Addendum to Plan of 52 Federal St. Portland, ME dated 2/6/2012 and received 2/7/2012

Address: 52 Federal St. Portland, ME

Applicant/ owner: Liv Chase and Brent Adler

The following corrections are to be noted in relation to the applicants submittal for building permit received February 7, 2012:

Rev.	A	B	C
Date	09-13-11	10-13-11	01-20-12
Remark	Issued for pricing	Issued for Permitting	Re-issued for Permitting
CODE:	IBC 2009		
TOWN:	Portland		
DATE:	09-12-11		
SCALE:	as noted		
DESIGNED:	LC		
DRAWN:	JC		
TITLE:	Garage Plans Schedules		
FILE:	A1.01		
SHEET:	A1.01

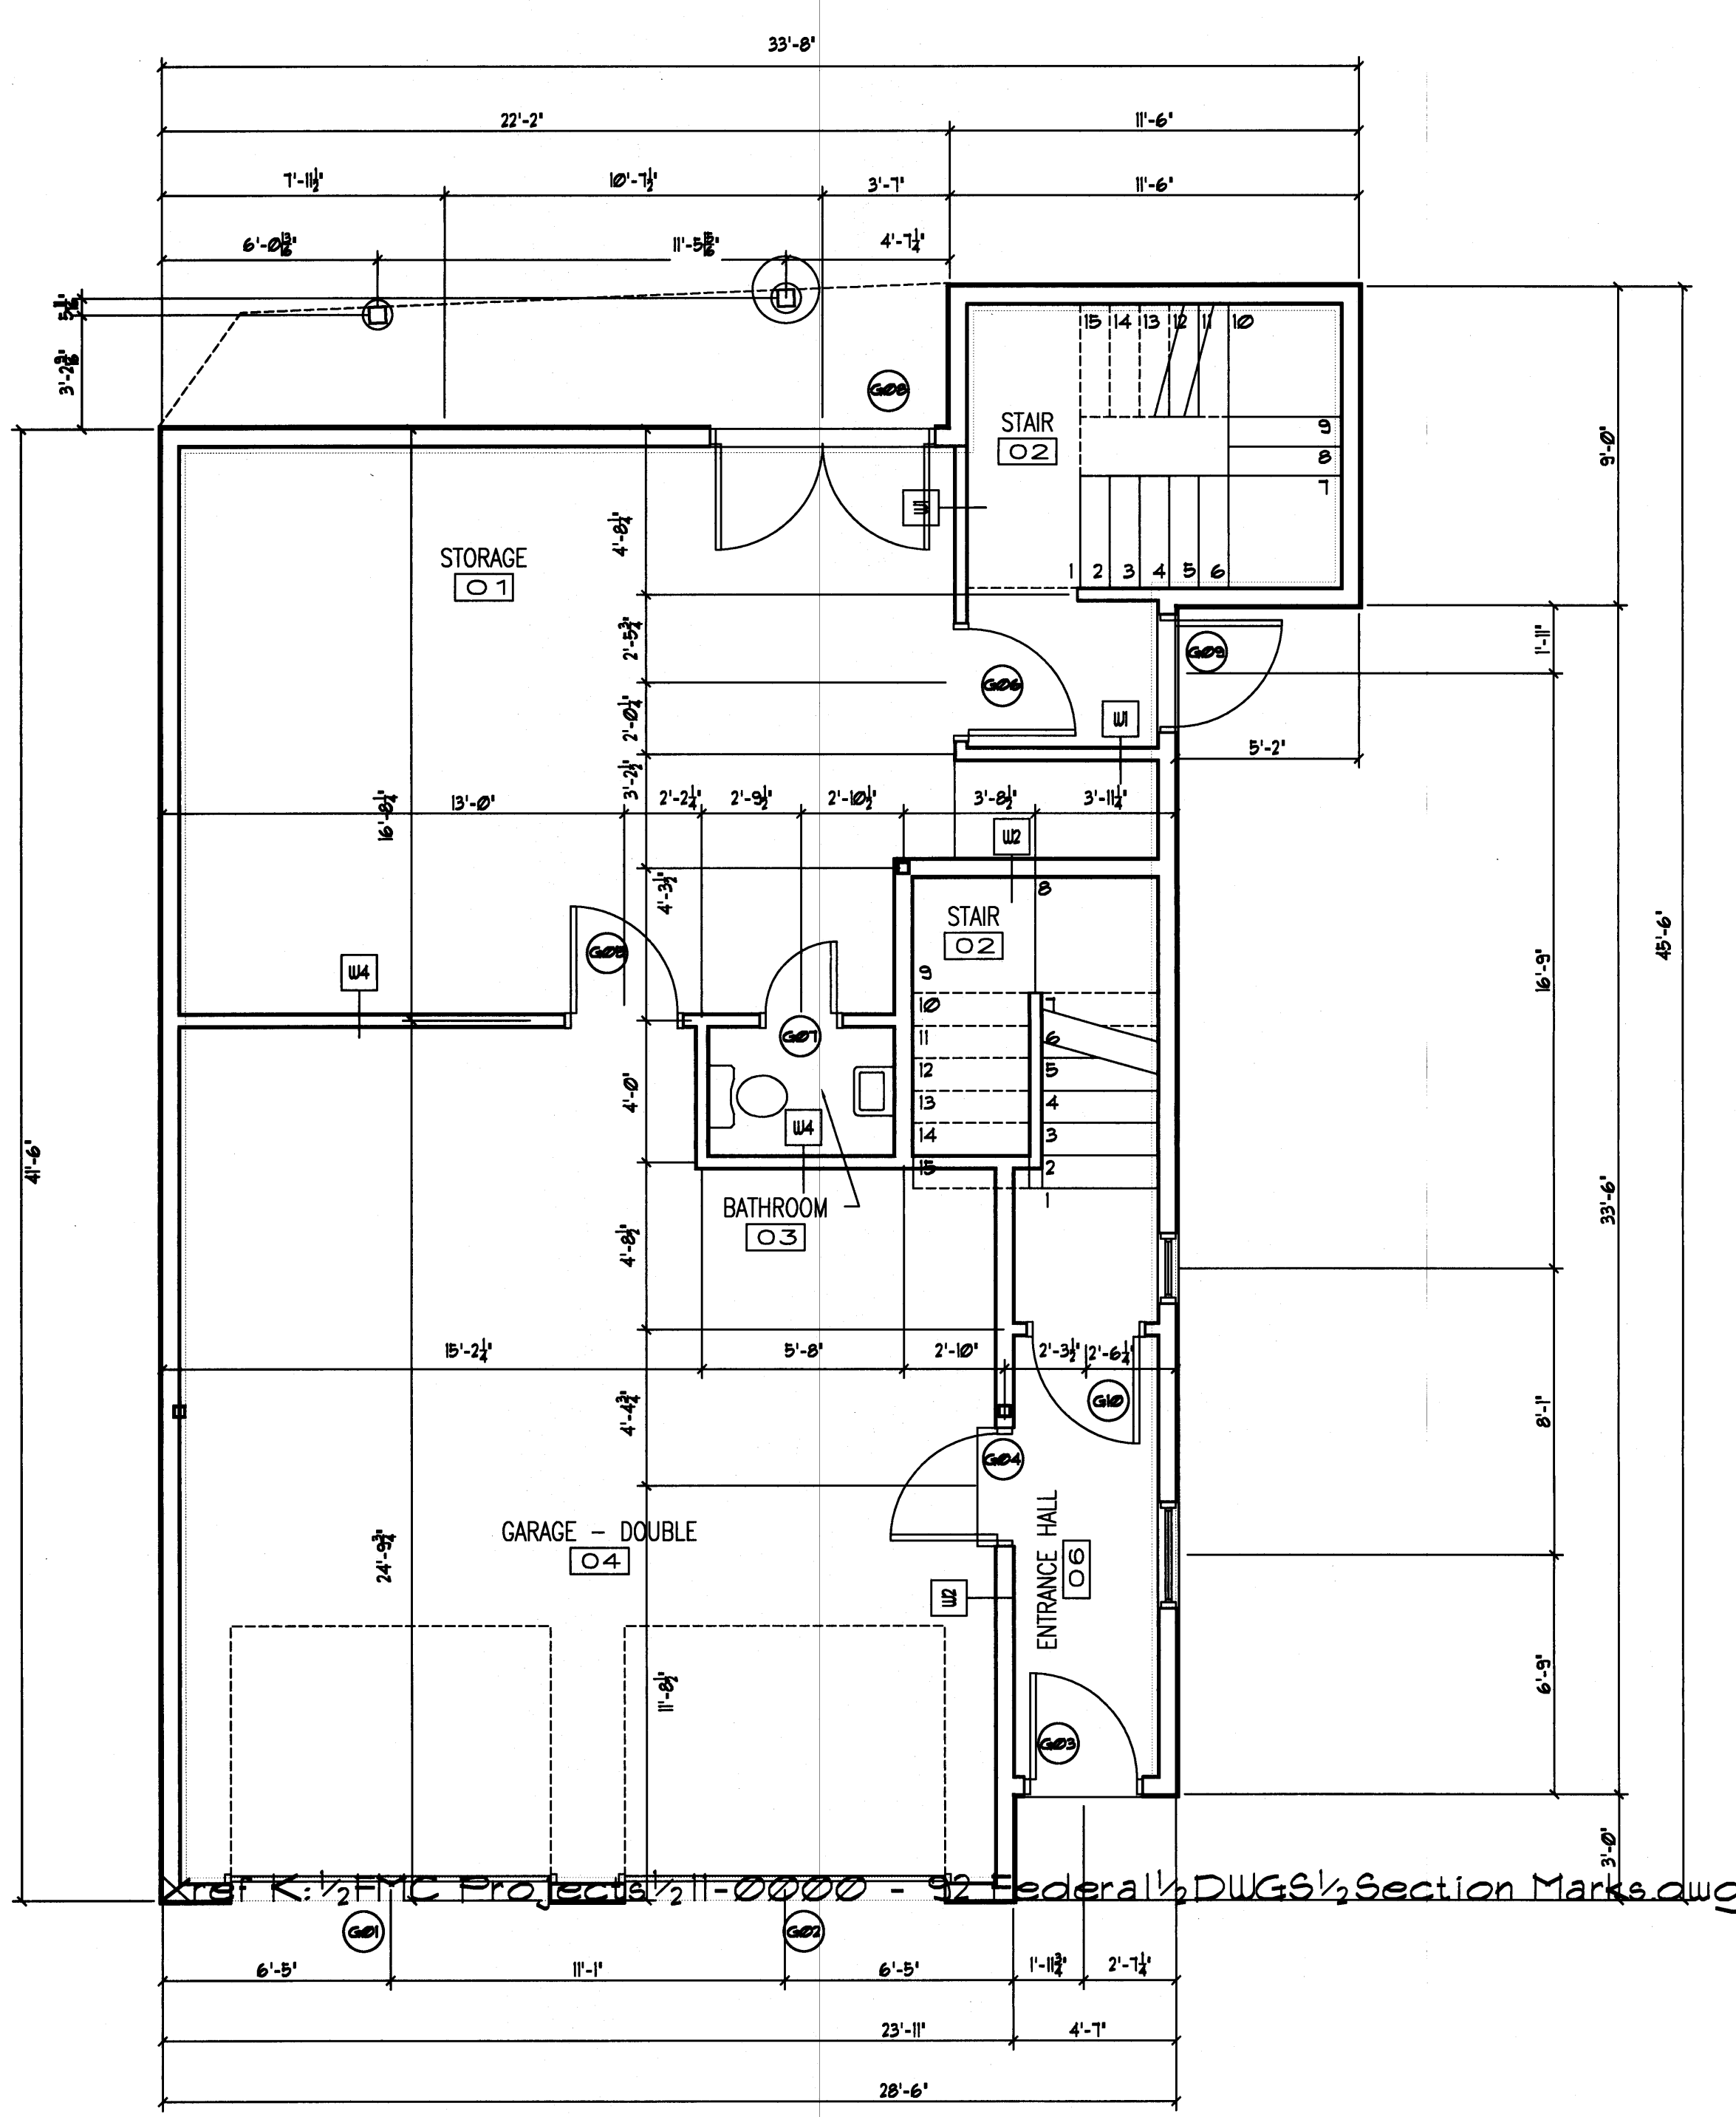
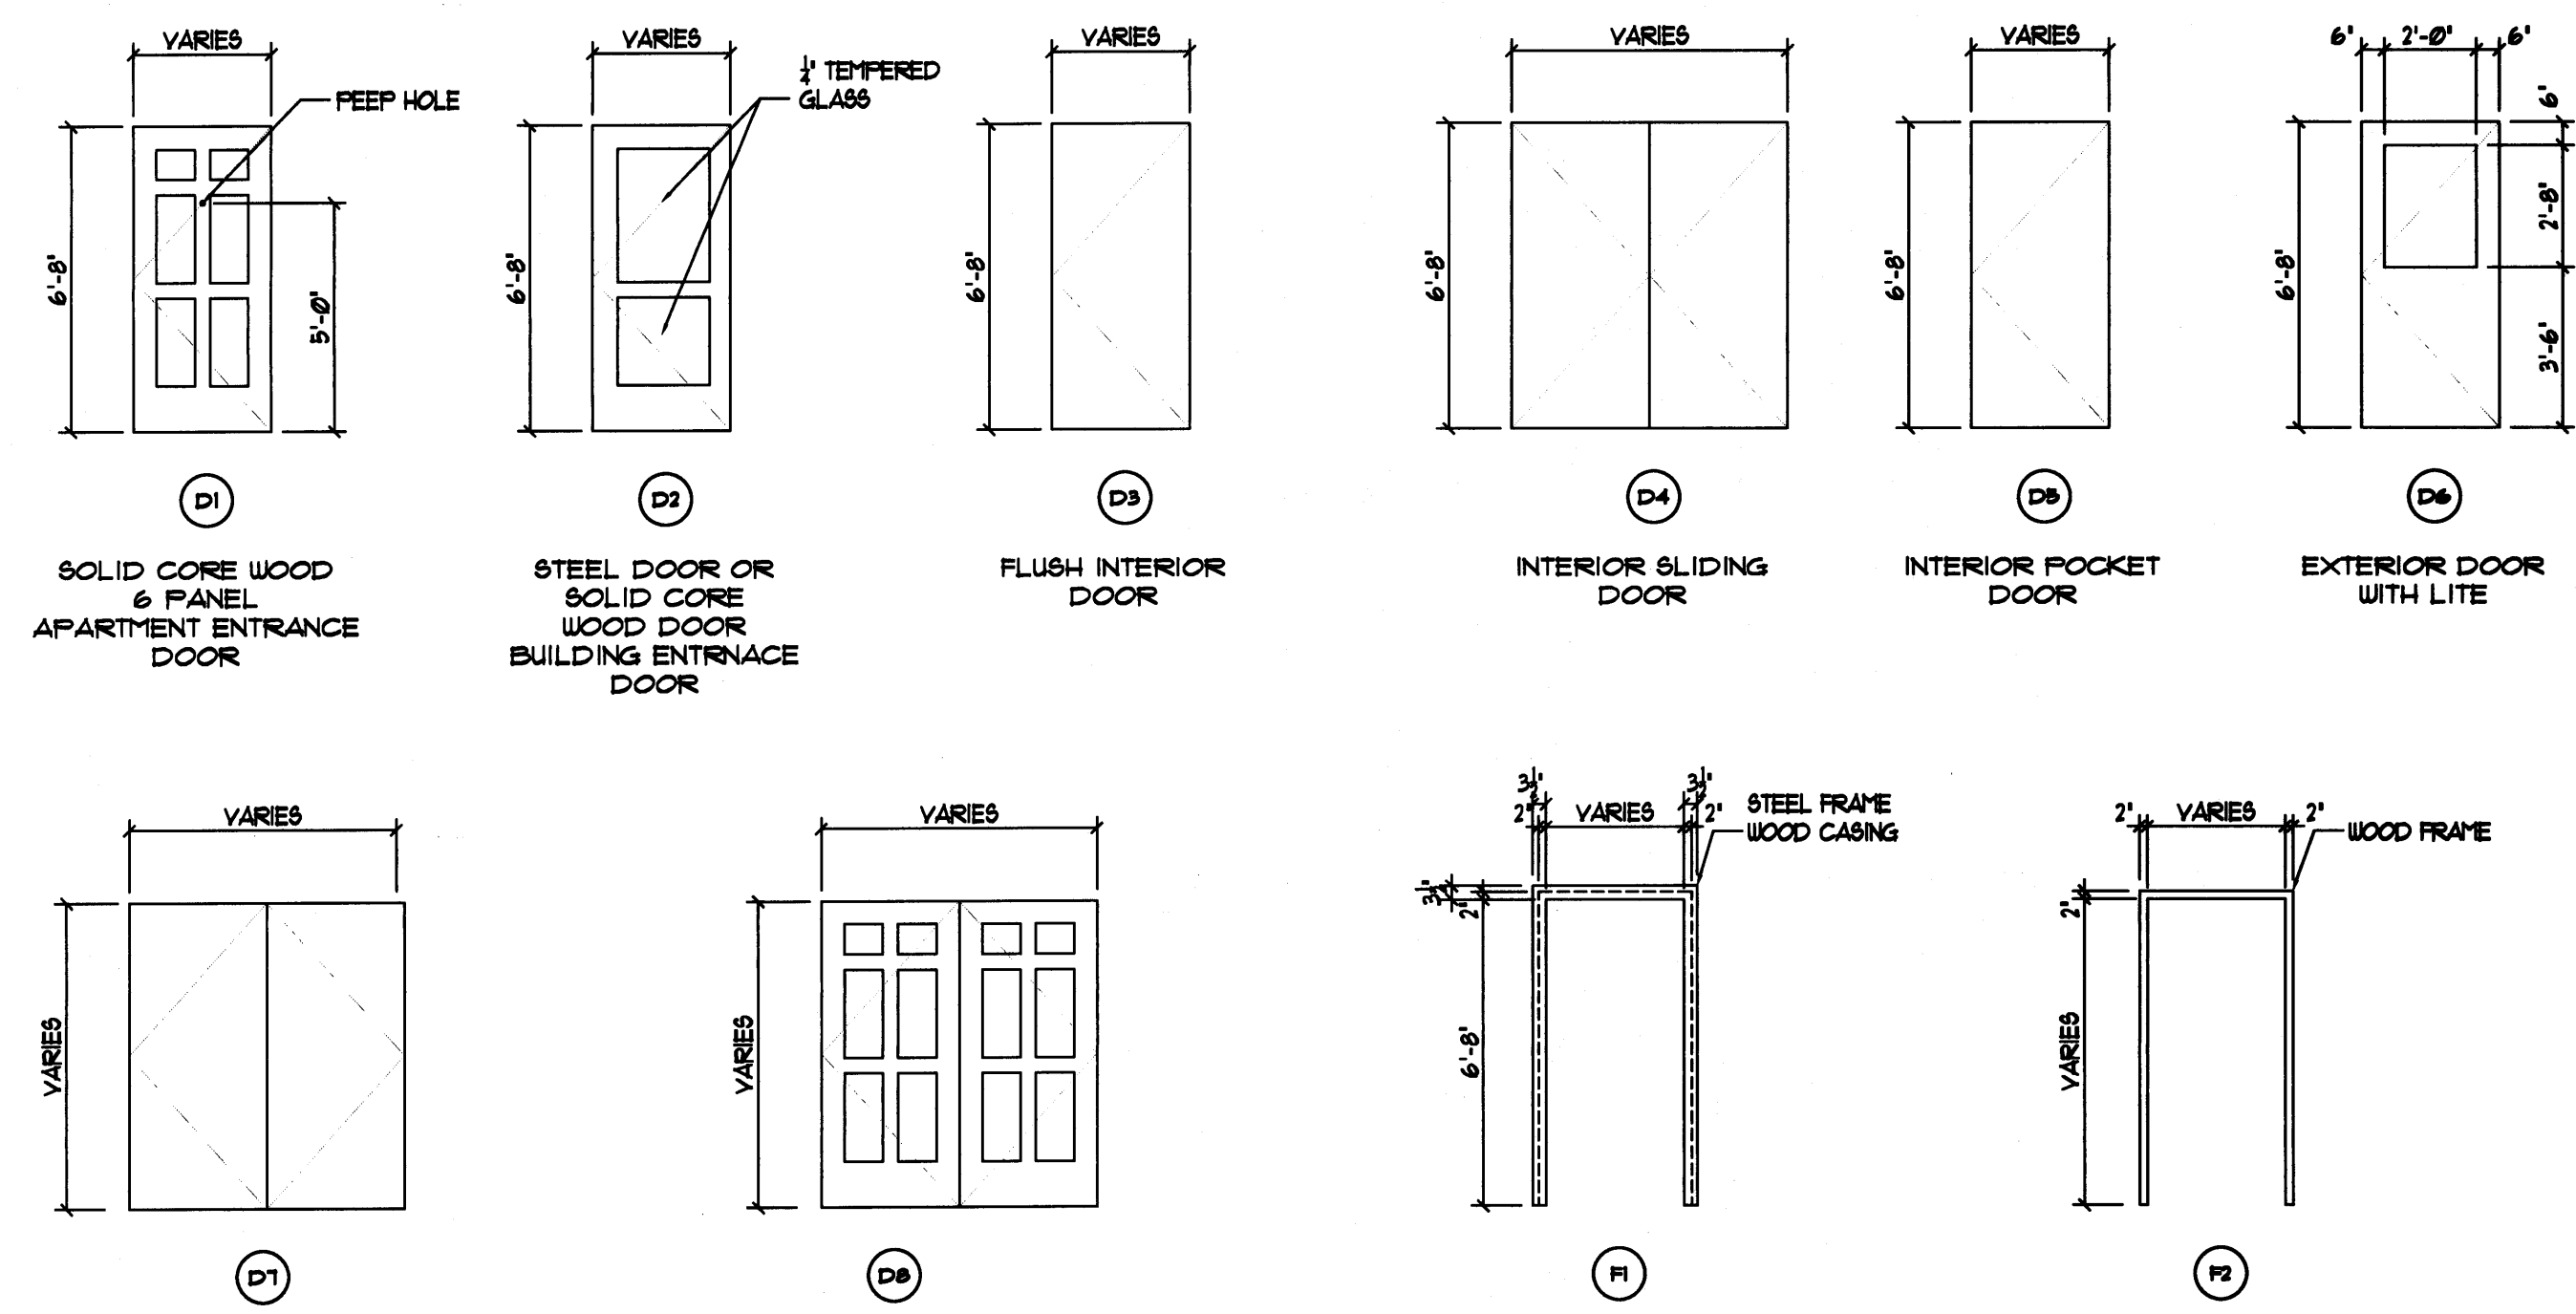
1. Cover Sheet A1.01
 - Fire resistant ratings for stairway enclosures = 2 hours not 1 hour
2. Garage Plans and Schedules Sheet A1.01
 - Door type G08 label is = to 1 hour
